May 22, 2017  
Kittitas County Community Development Services  
411 N. Ruby St, Suite 2  
Ellensburg, WA 98926  
RE: Rezone PD-16-00001

SHEET NUMBER
A1.0

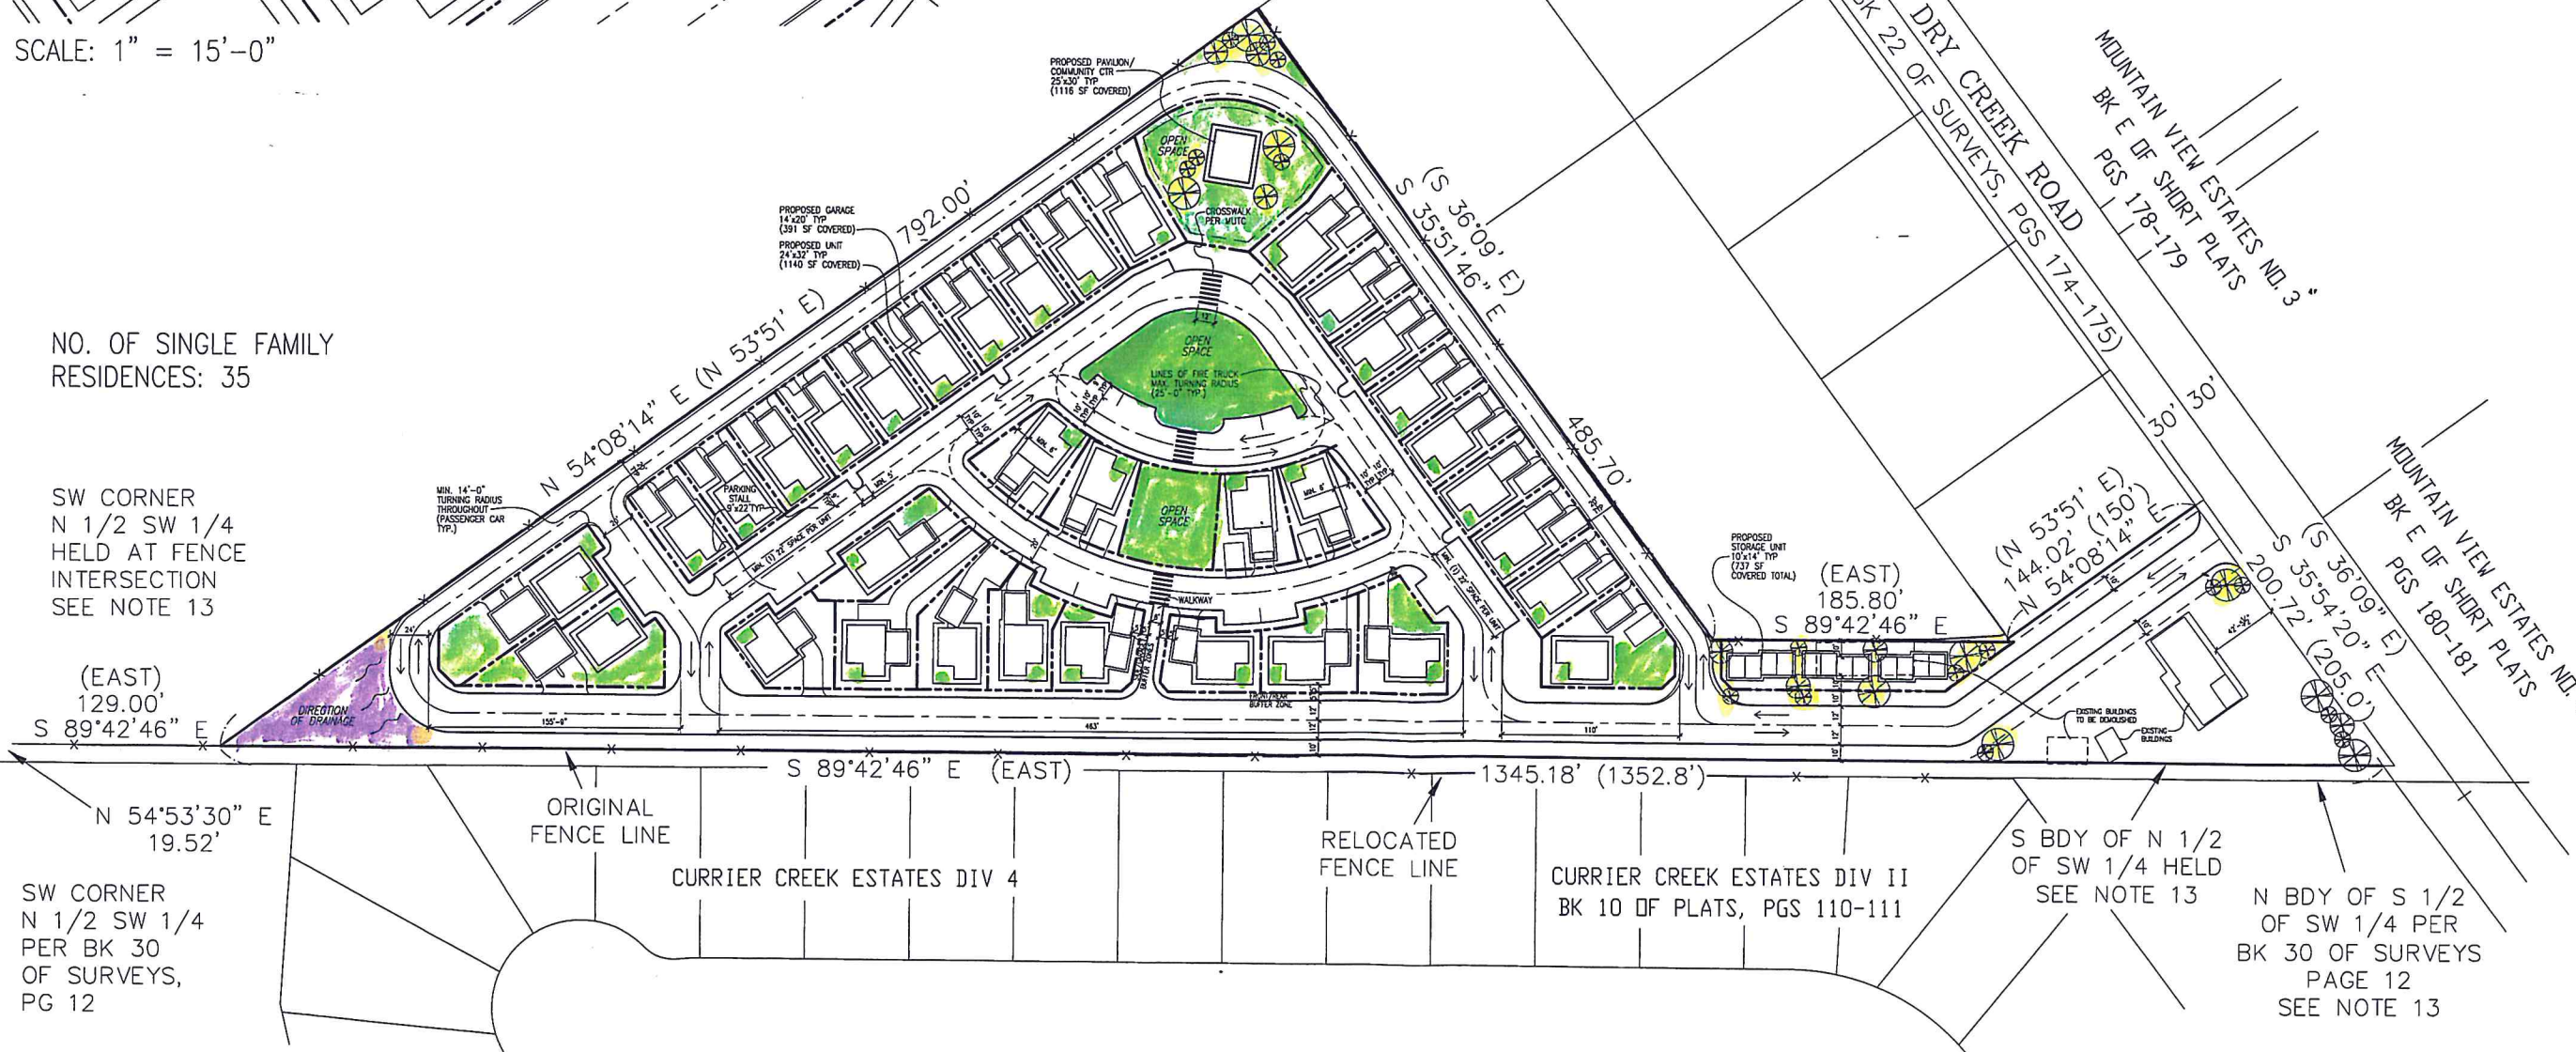
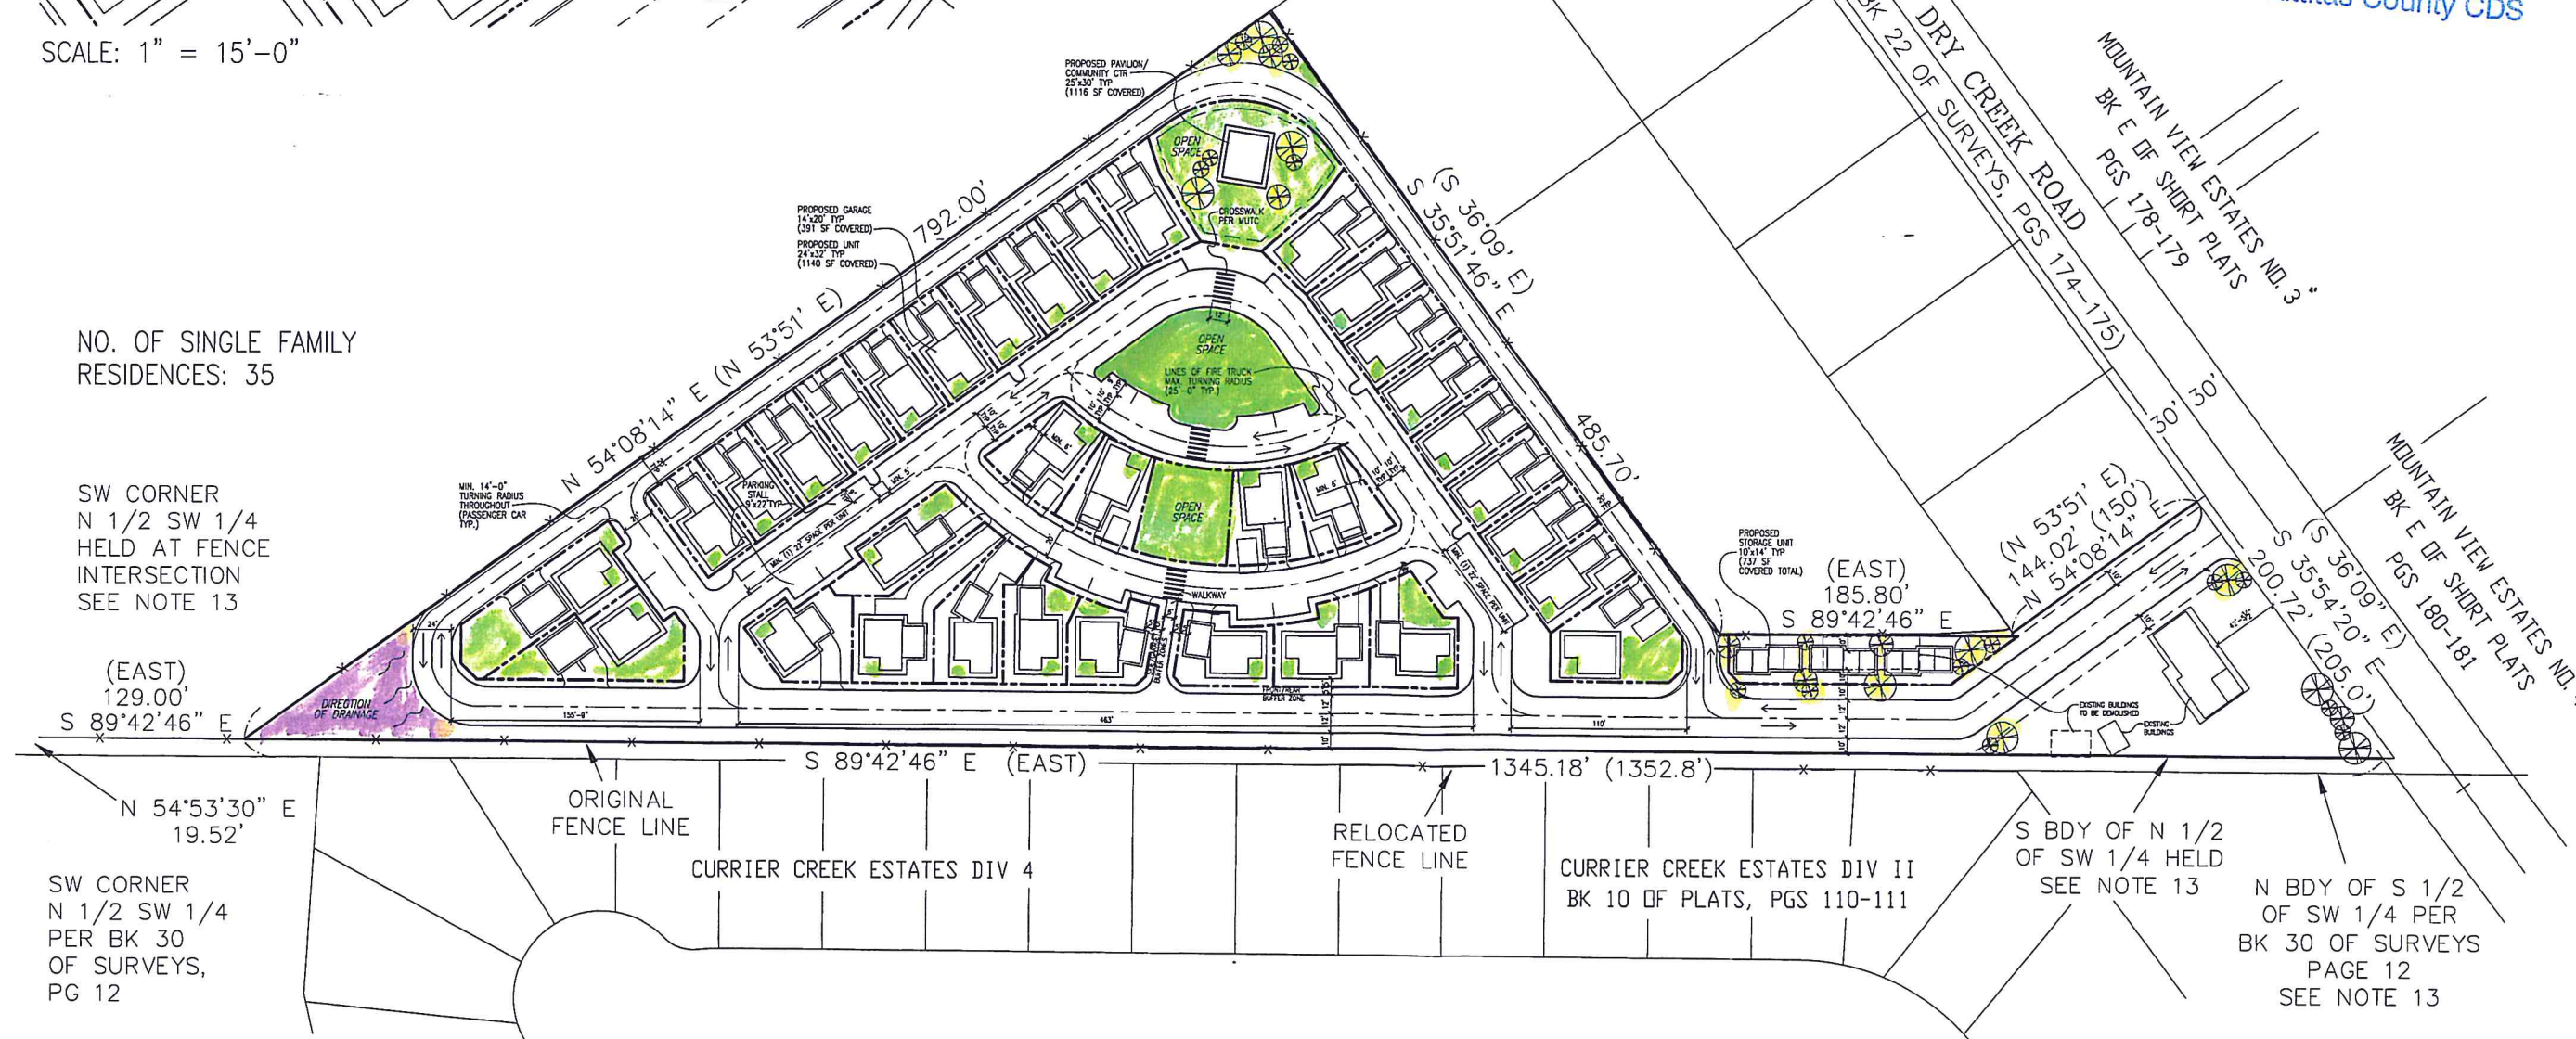
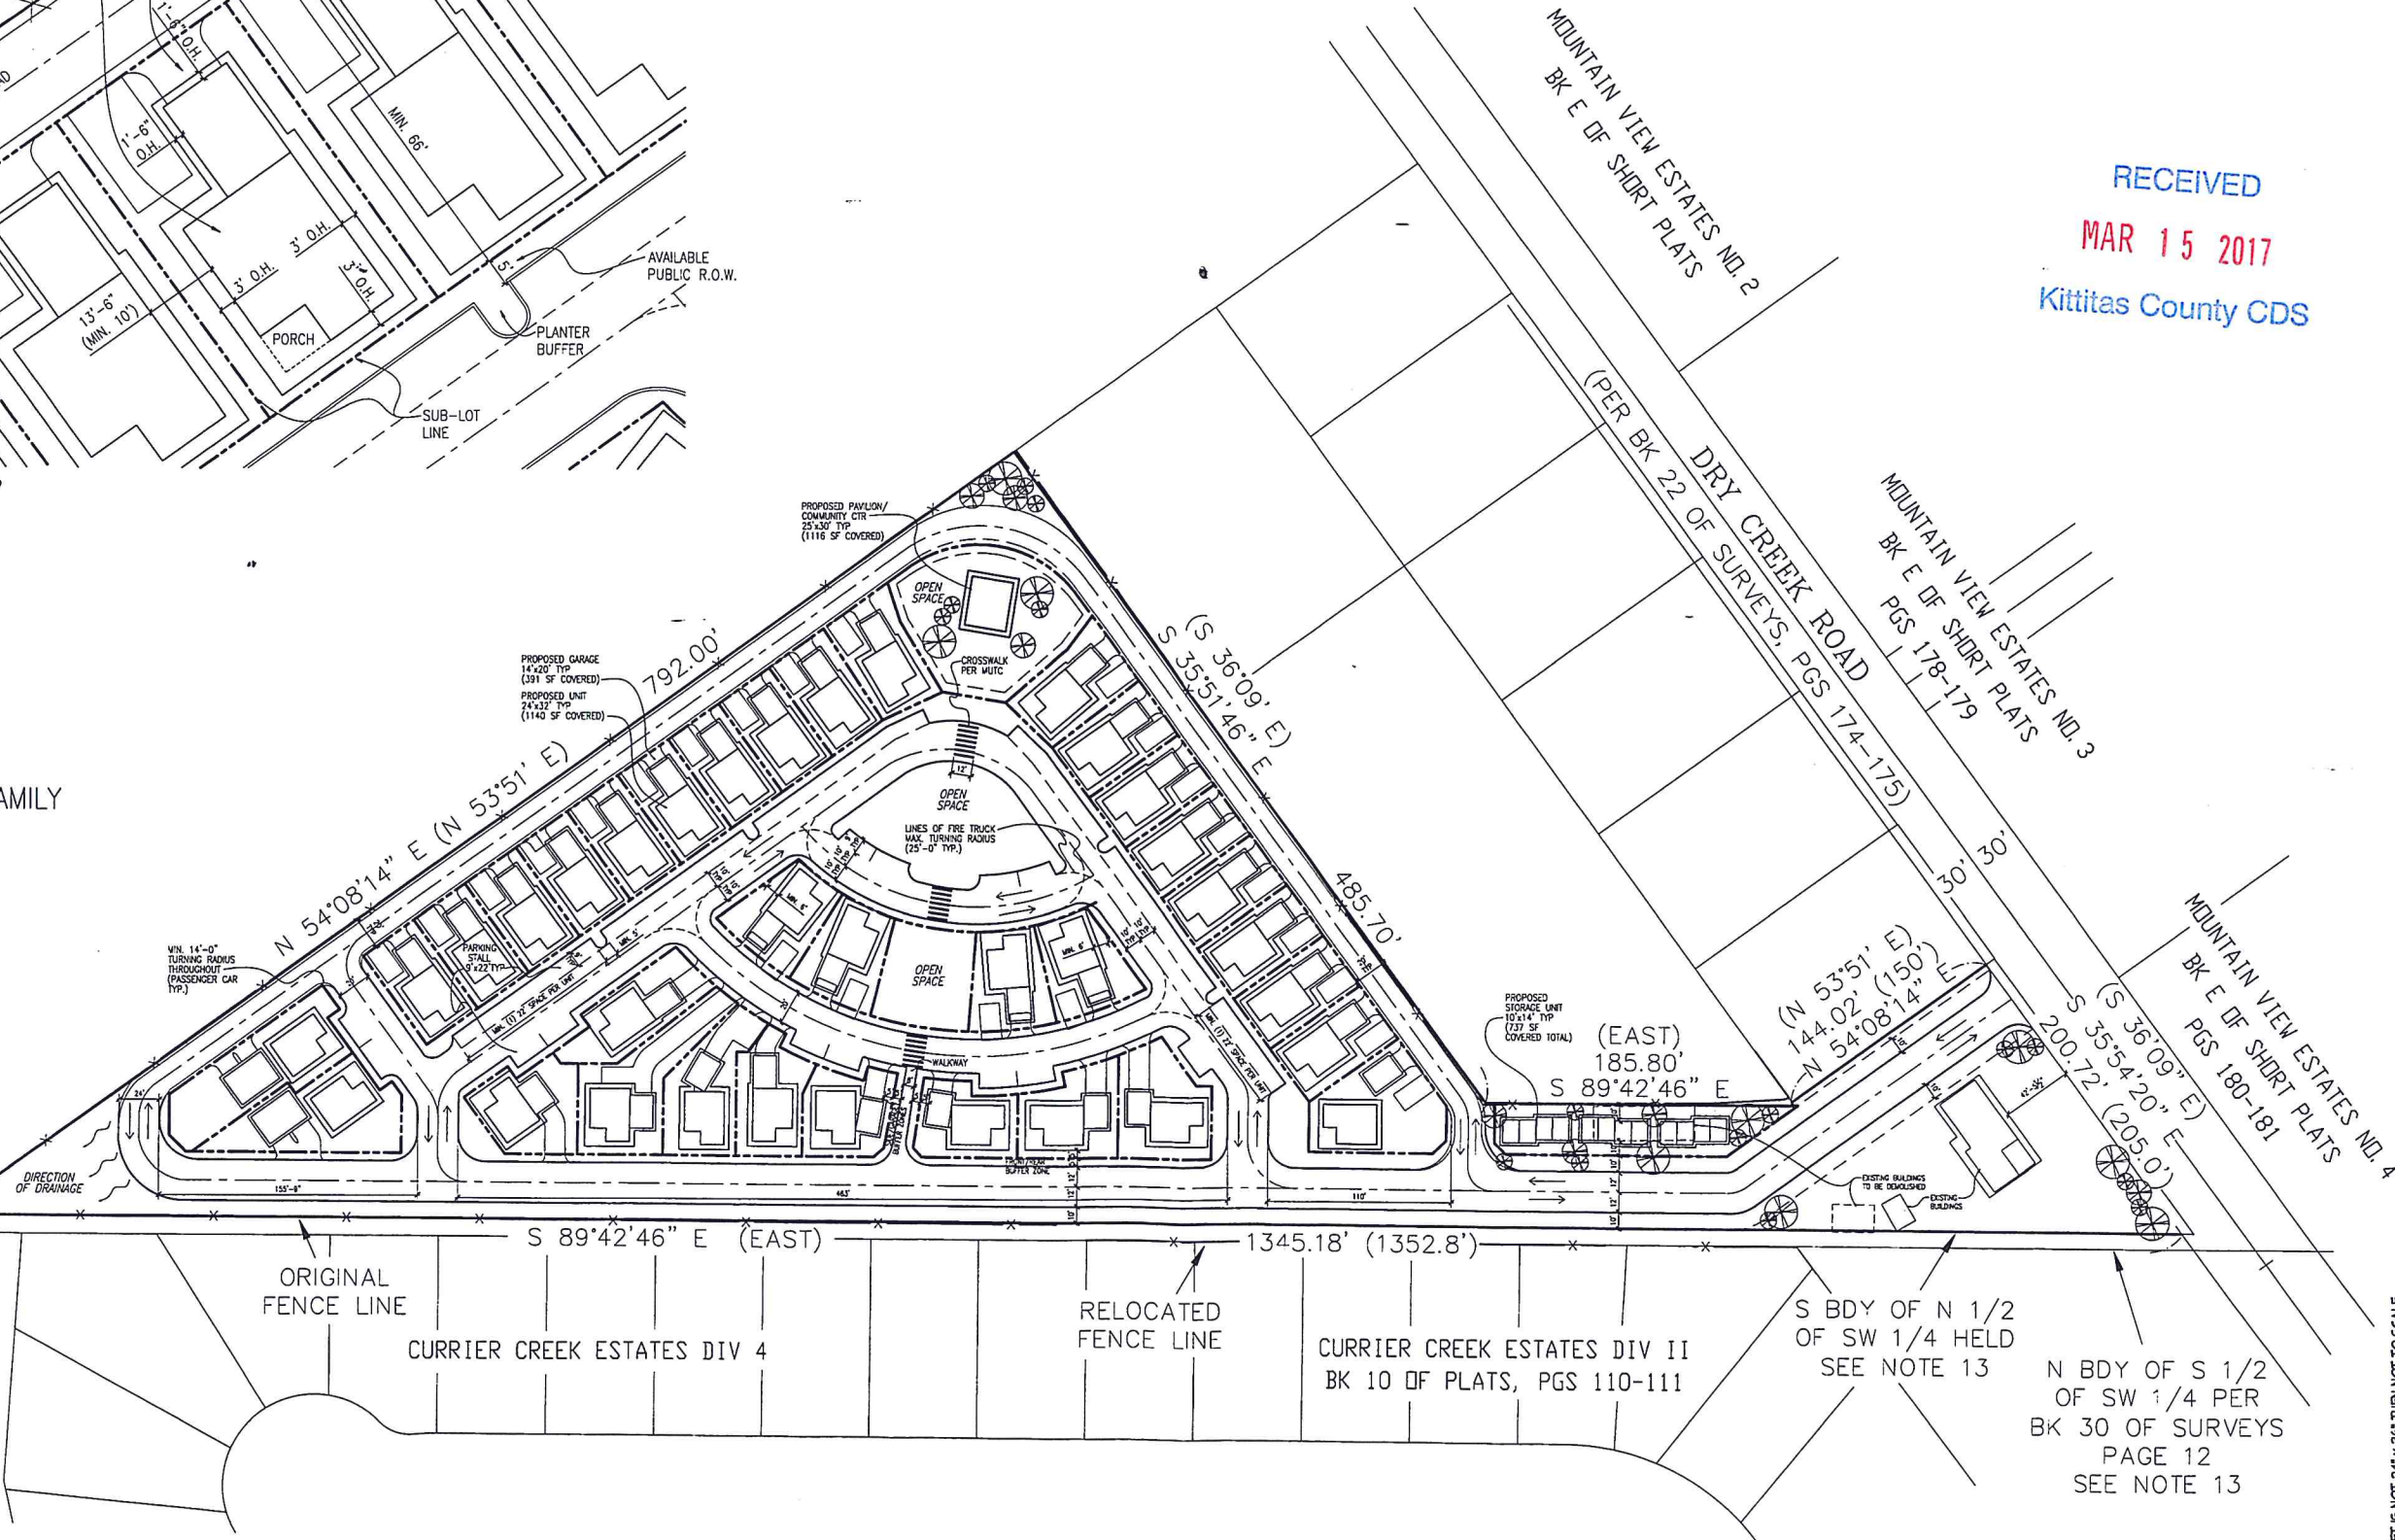
1. A corner of the property touches on Currier Creek, a creek that has seen flooding in the past two years. We are learning the hard way that simply turning empty land into high density housing in this part of the valley can create water problems and a study of how high density housing will affect water runoff here simply must be done before this re-zone is approved.

2. The parcel seems to be land locked, with no access road. It is impossible to intelligently anticipate how this development might affect traffic without some idea of how people will come and go.

3. I could find no plan for division of the property into parcels, so it is impossible to gauge the ultimate density of the development or the effects of such housing on low density neighbors. Certainly some plan for housing parcels must be presented to make an intelligent decision. There will certainly need to be some set-backs for the surrounding low density homes.
